218948

Appendix A – Response to Submissions

Extracts from Government agency and authority submissions and submissions from the general public received in relation to SSD 10342, and a response to each of these matters, has been provided in the sections below.

Figure 6: Construction traffic routes and worst affected residences.

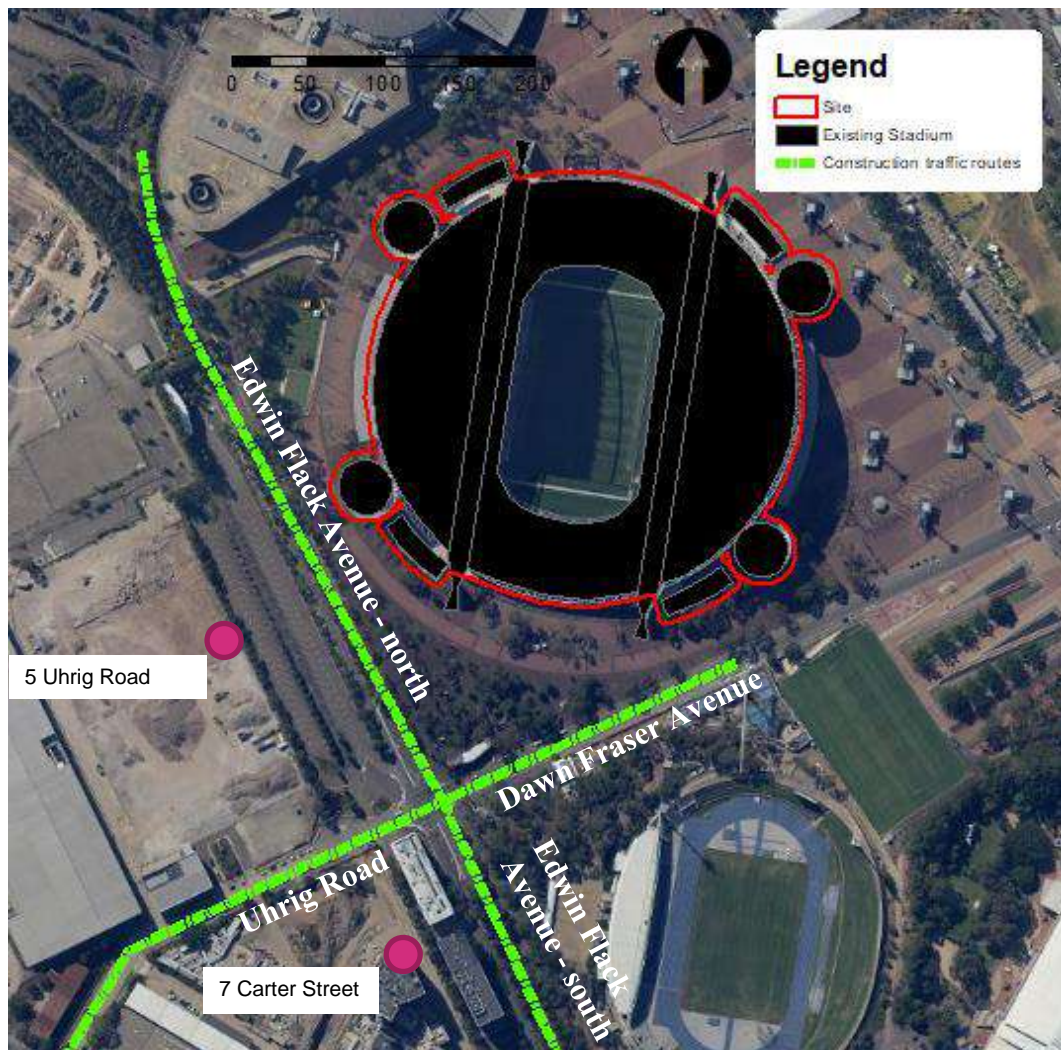
EPA4	<p>b) The Noise Report has not considered all of the construction traffic routes that are included in the Transport Impact Assessment and therefore it is not clear if all potentially affected sensitive receivers have been assessed. The Noise Report must include an assessment of all of the proposed construction traffic routes.</p>	<p>Section 3.5 of the revised Noise and Vibration Impact Assessment at Appendix C of this Response to Submissions includes one additional outbound construction traffic route travelling south-east along Edwin Flack Avenue. The assessment demonstrates that increases in road traffic noise levels due to construction are predicted to be 'minor', i.e. within 2dB. This is based on a conservative assessment assuming a maximum number of heavy and light vehicles arrive on site simultaneously.</p>
EPA5	<p>c) The construction traffic noise assessment has only considered noise levels during daytime. However, construction is proposed to start at 7am, therefore construction related vehicles may be travelling to the site prior to 7am, during the night period. The applicant must confirm the times when workers will be travelling to the site and amend the assessment accordingly.</p>	<p>Section 3.5 of the revised Noise and Vibration Impact Assessment at Appendix C of this Response to Submissions includes an assessment of increases in noise due to additional construction traffic during both the 6-7am period as well as the 7-8am period. These assessments assume a worst case scenario of light and heavy vehicles arriving on site. The assessment demonstrates that increases are predicted to be minor, i.e. less than 2dB.</p> <p>No workers will be permitted to queue outside the site or to access the site prior to 7am. This will be specified in the detailed Construction Pedestrian Traffic Management Plan to be prepared with the appointed contractor and relevant stakeholders prior to the commencement of works on the site. No further noise mitigation is considered necessary.</p>

Figure 8: Speaker configuration for north stage mode (left), centre stage mode (middle) and south stage mode (right)

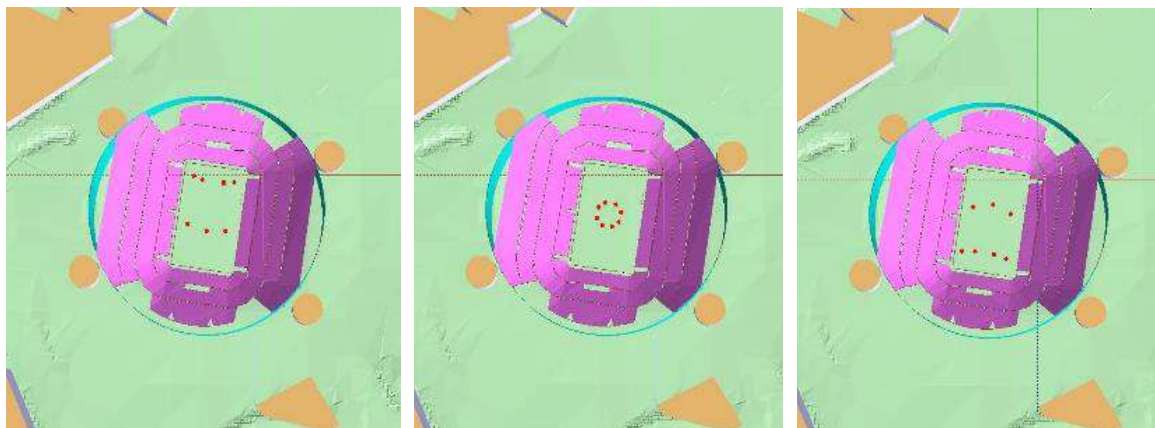
EPA7	<p>b) It is not clear from Section 4.2 of the Noise Report how the stadium's public address systems have been included in the noise assessment for different concert or sporting events. The applicant should provide a clarification of all the different types of sound systems considered in the noise assessment.</p>	<p>Details of the public address system were not considered necessary to demonstrate changes in noise level, since no change to the public address system is proposed.</p> <p>For completeness, modelling of the public address systems is included in Section 4 of the revised Noise and Vibration Impact Assessment at Appendix C to this Response to Submissions.</p>
EPA8	<p>c) The SEARs required an assessment of pyrotechnic noise which is not included in the assessment. The Noise Report must include this assessment.</p>	<p>A qualitative assessment of pyrotechnics is included in Section 4.4.1 of the revised Noise and Vibration Impact Assessment at Appendix C of this Report. As per the comment above relating to PA systems, no changes to the use of pyrotechnics from the current stadium are proposed.</p>

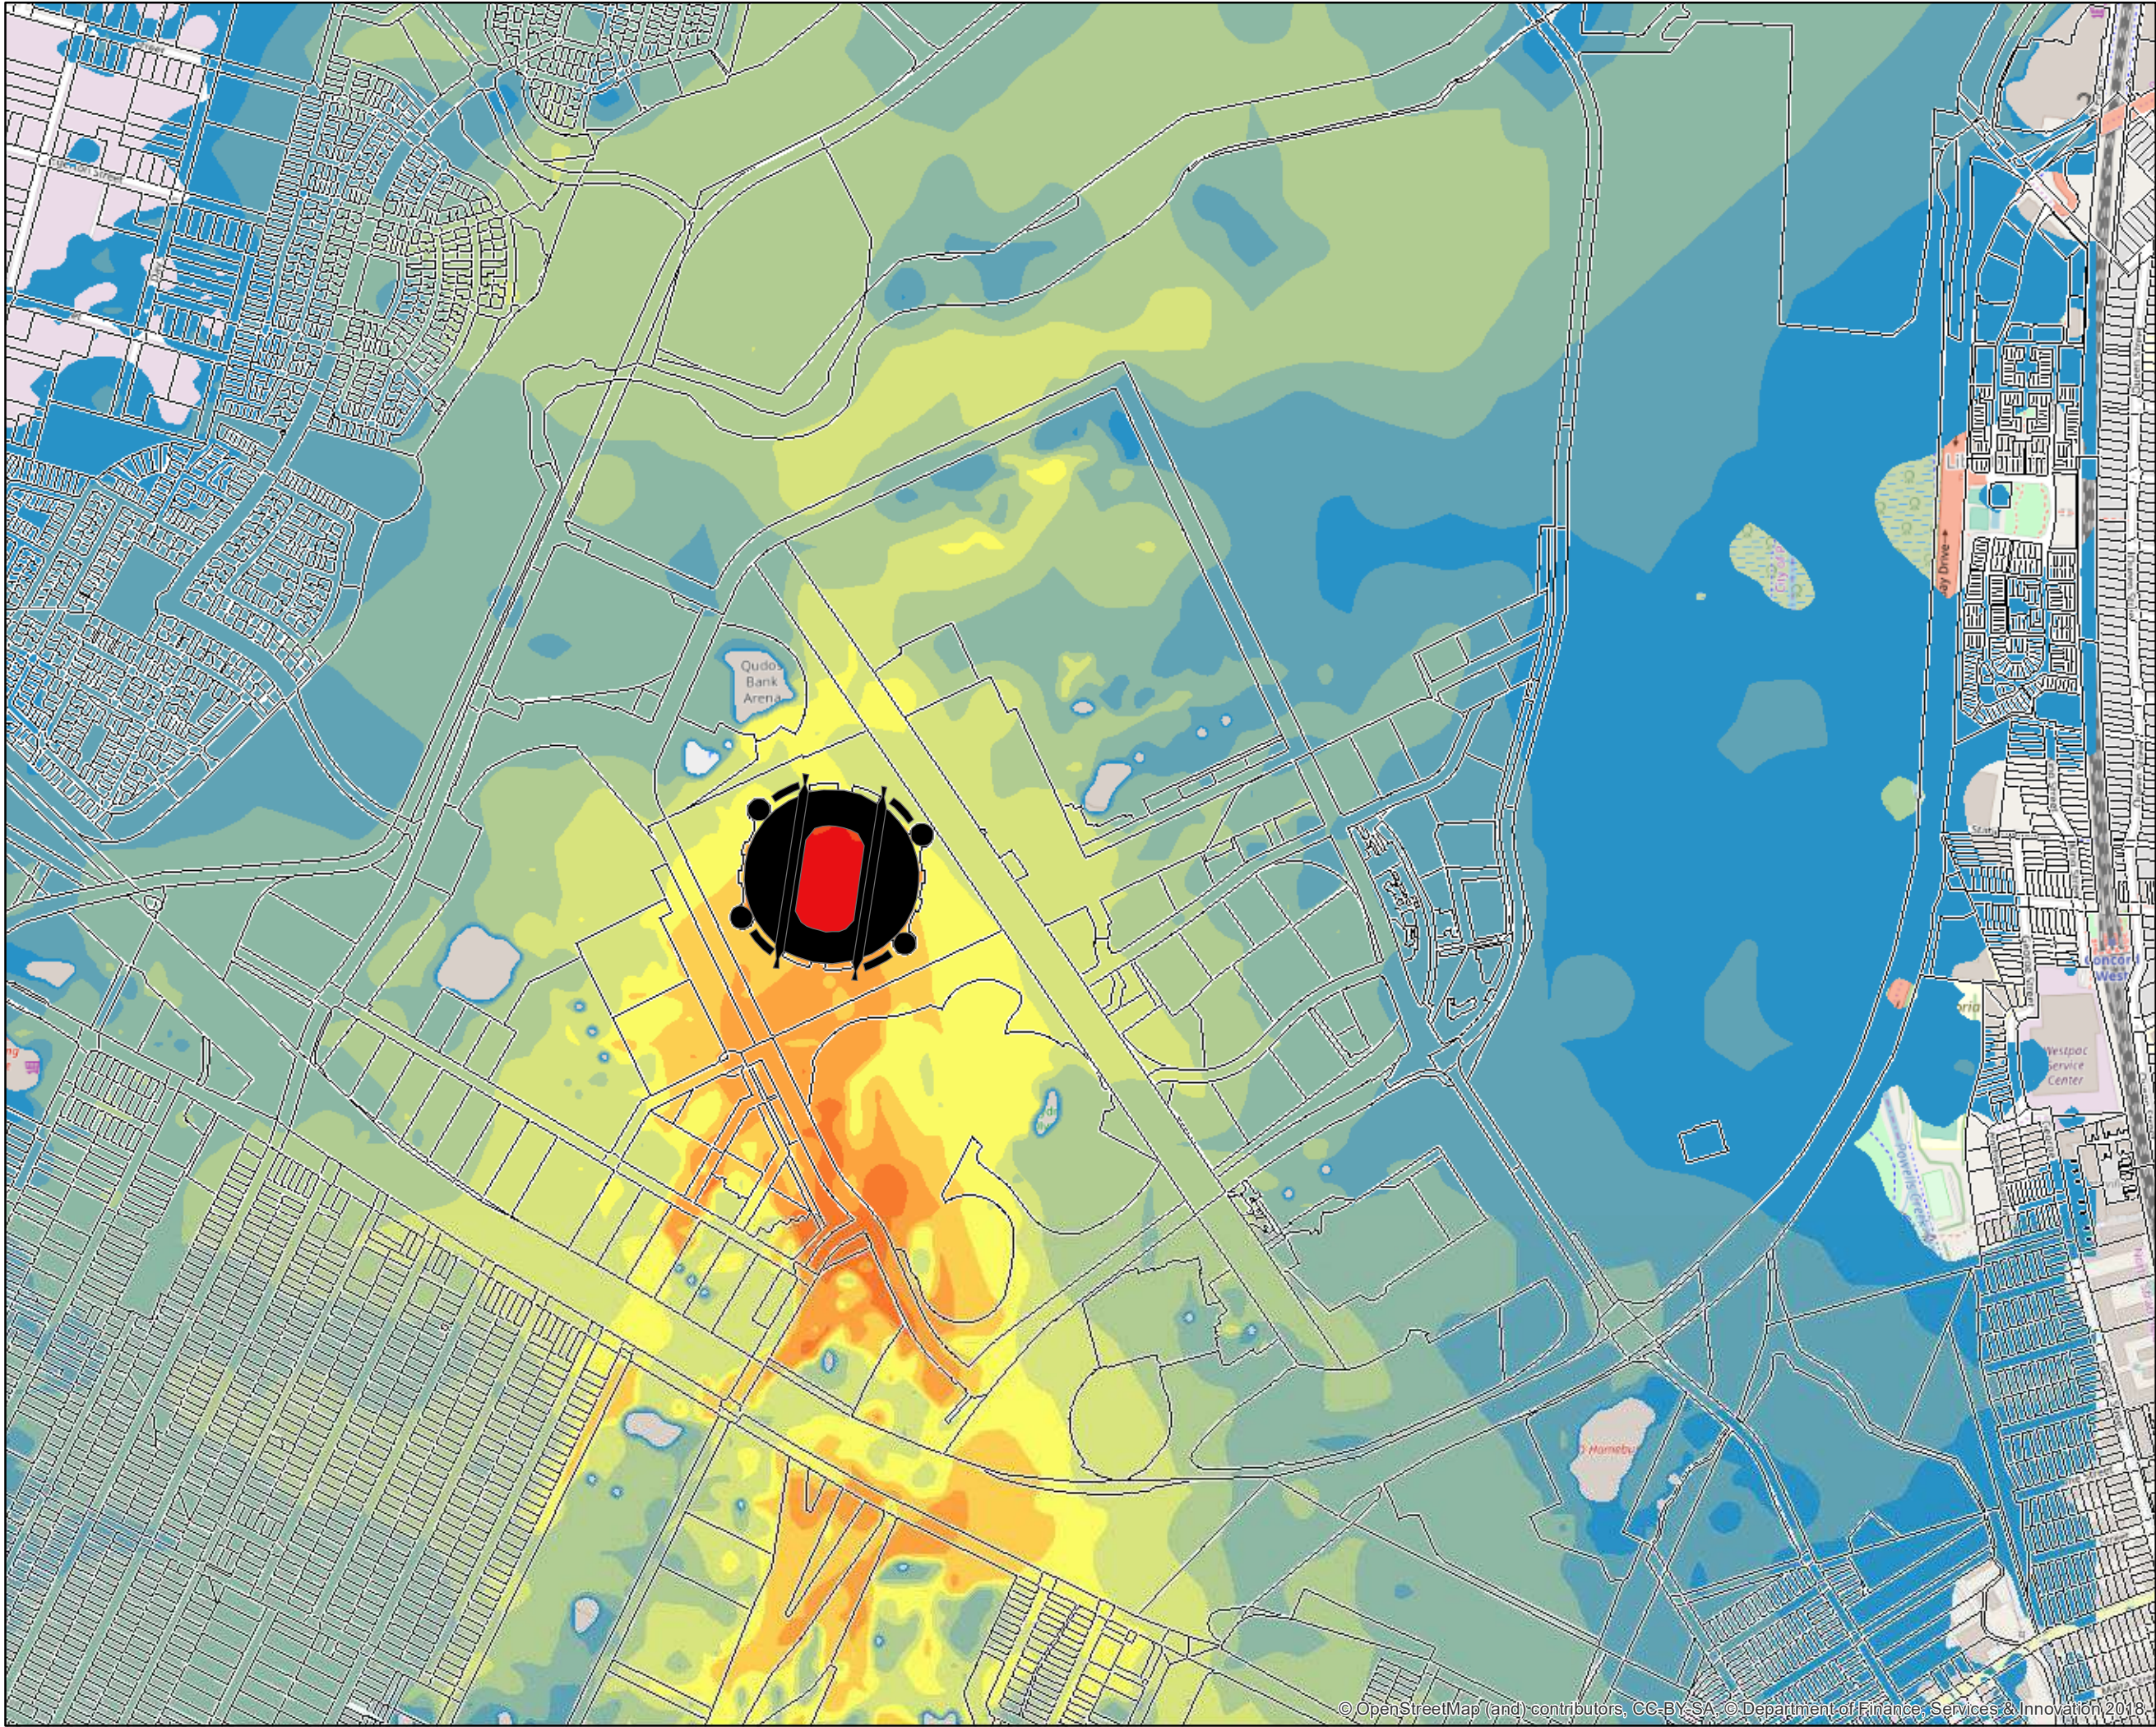
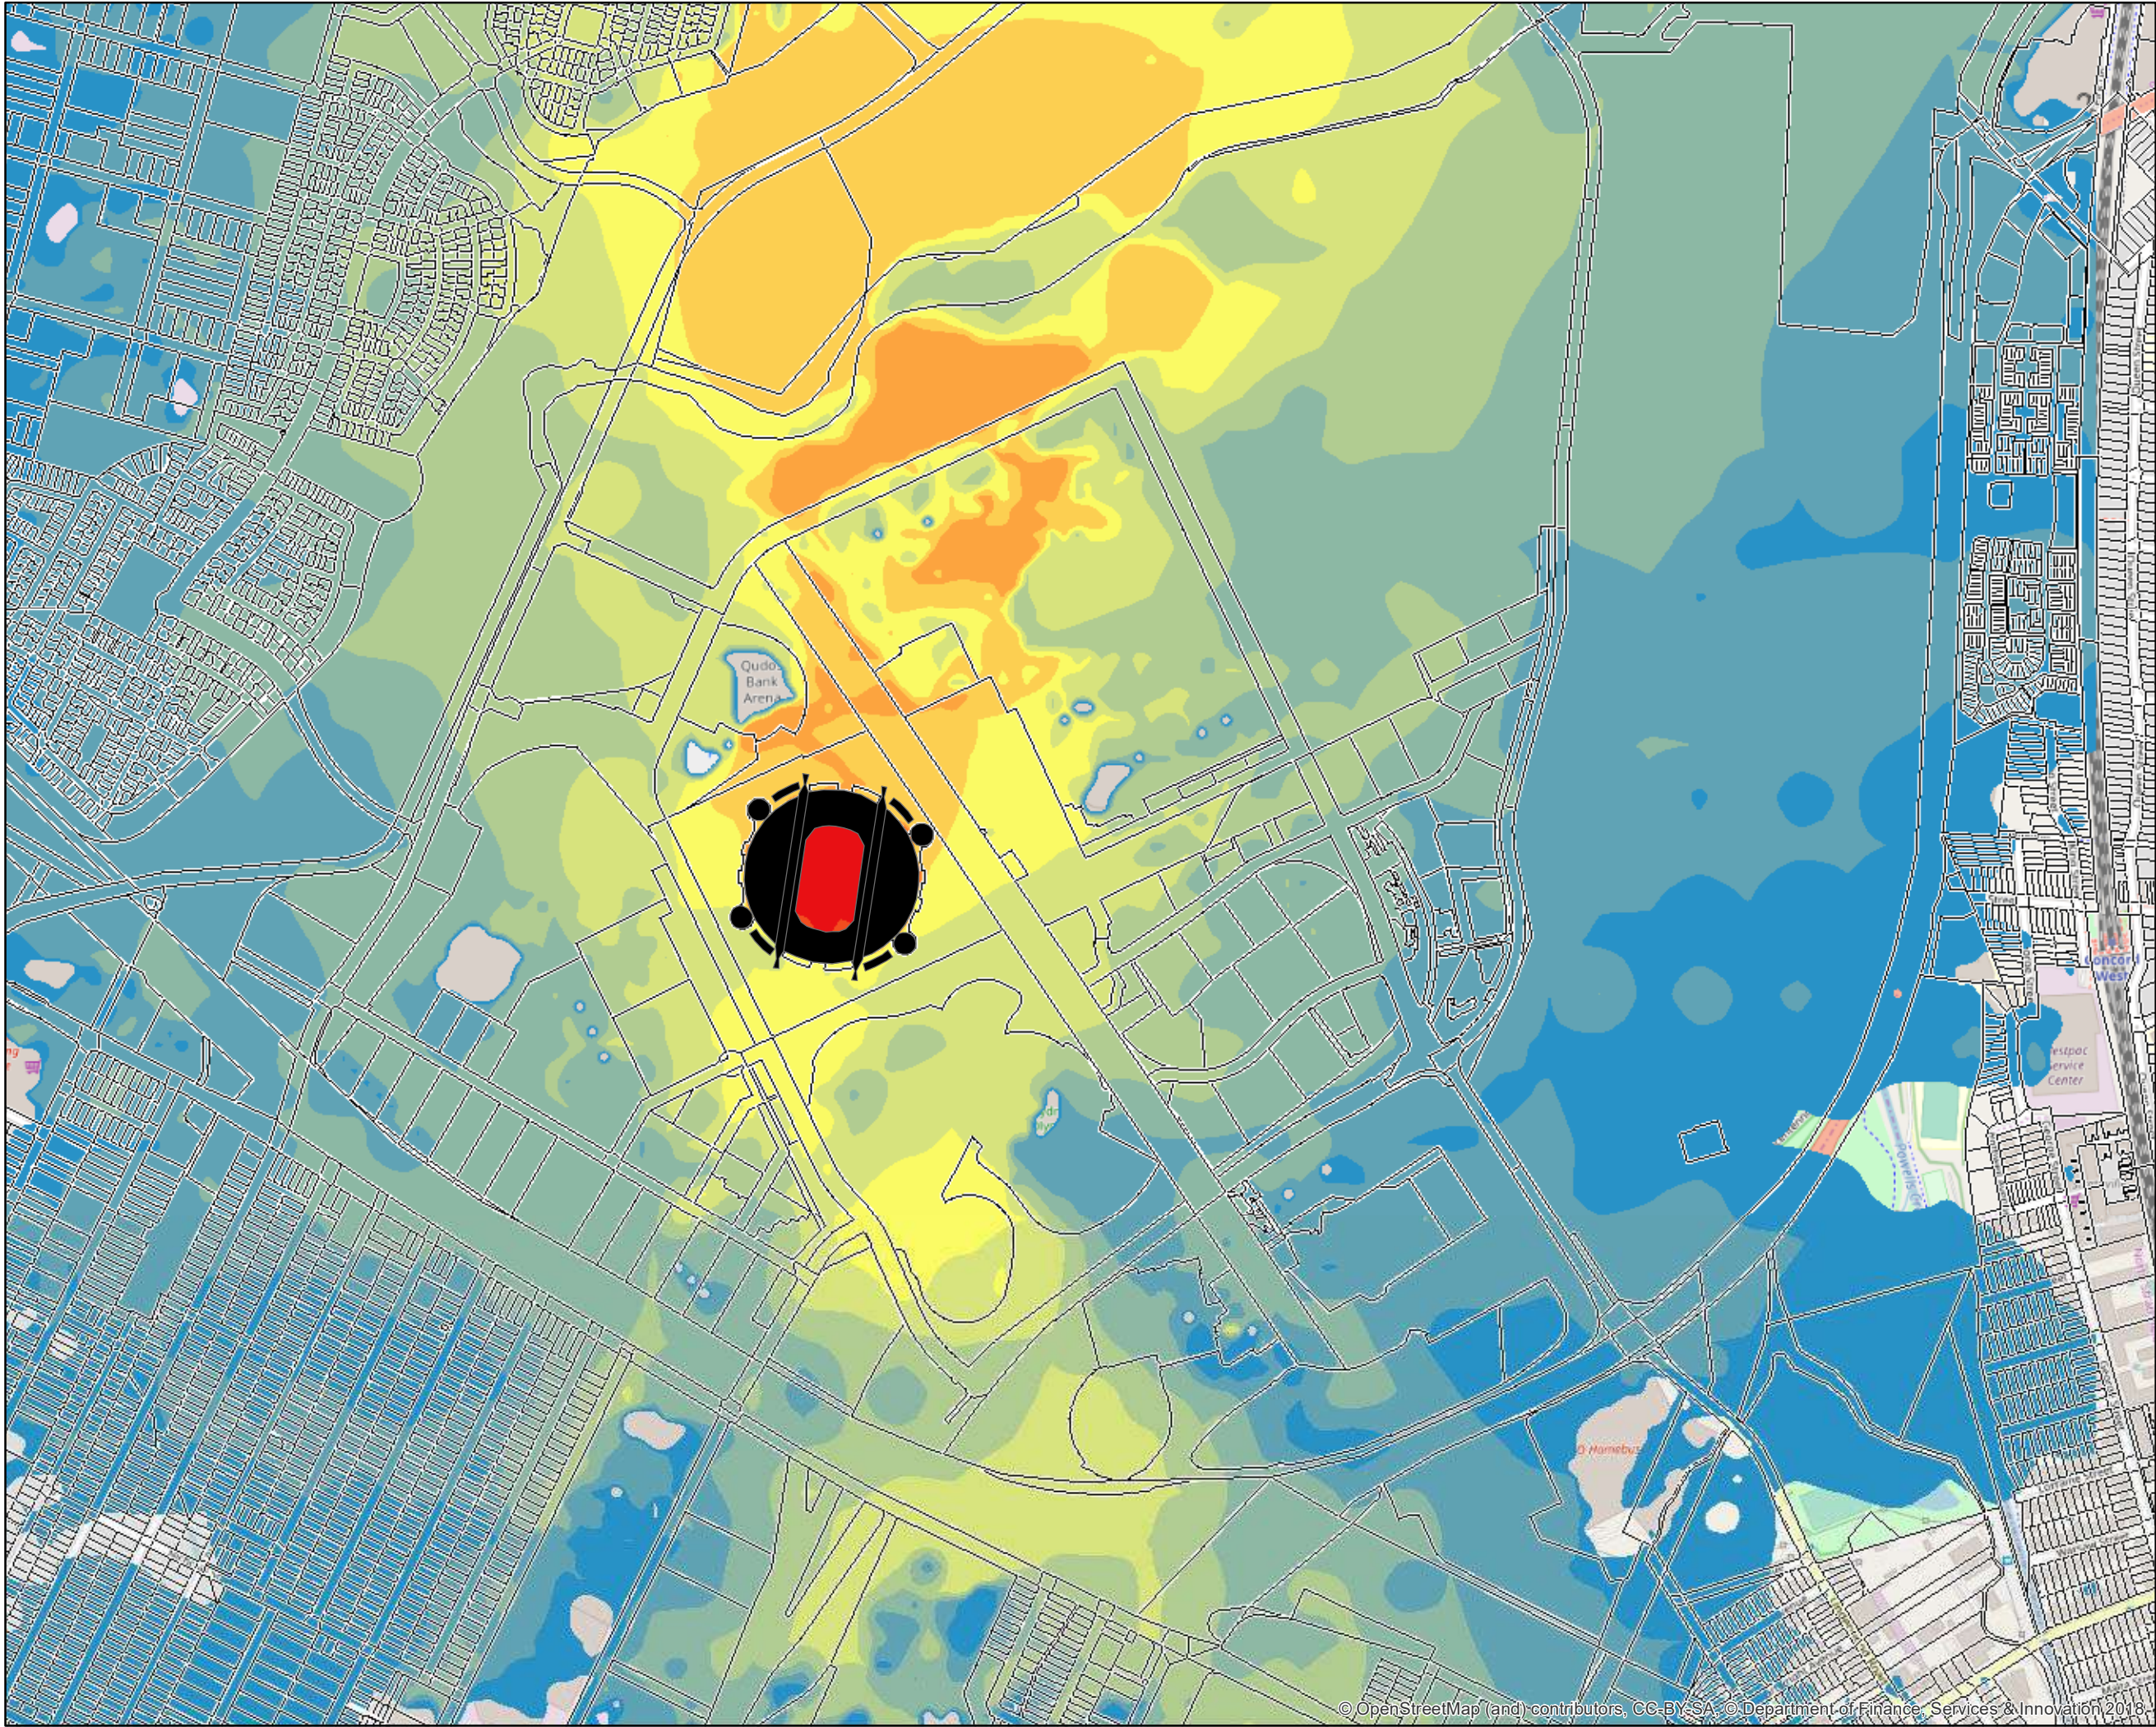
No.	Extract	Comment
EPA6	<p>Event noise management</p> <p>a) The Sydney Olympic Park Authority Act 2001 establishes the Sydney Olympic Park Authority (SOPA) as the Appropriate Regulatory Authority (ARA) for the stadium. The Act also includes a noise limit for events as the maximum permissible noise level from event noise of $L_{10,15min}$ 85 dB(A) at the nearest residential façade. The Noise Report has only presented a change in noise level in $L_{eq,15min}$. The EPA notes that the proposed modifications are generally minor in nature with regard to noise emissions. The Noise Report presents a comparative noise assessment for operational noise from events at the stadium. The predicted difference in noise levels presented in the report is relatively minor. The assessment does not present predicted noise as an absolute noise level and therefore the noise level potentially experienced by receivers adjacent to the stadium is not included in the report. This means that the footprint of noise impacts is not defined in the report and, as a result, an analysis of measures which could be implemented to reduce the noise footprint of the stadium is not able to be undertaken.</p>	<p>Section 4 of the revised Noise and Vibration Impact Assessment at Appendix C of this Response to Submissions assesses the proposal against the SOPA Act 2001 noise limits. Receivers which existed at the time the Act was implemented have been assessed to $L_{10,15min}$ 85 dB(A) at the nearest residential façade. Results for both concert and sporting events have been assessed, with three typical concert stage configurations modelled. Predicted levels at receivers which have been constructed since the Act was brought in have also been presented for reference, and noise contours generated in Appendix E.</p> <p>Results show noise levels from both the existing ANZ Stadium and the proposed Stadium Australia comply with SOPA Act 2001 noise limits.</p> <p>The footprints of event noise impacts are also presented in event noise contours that are included at Appendix C.</p>
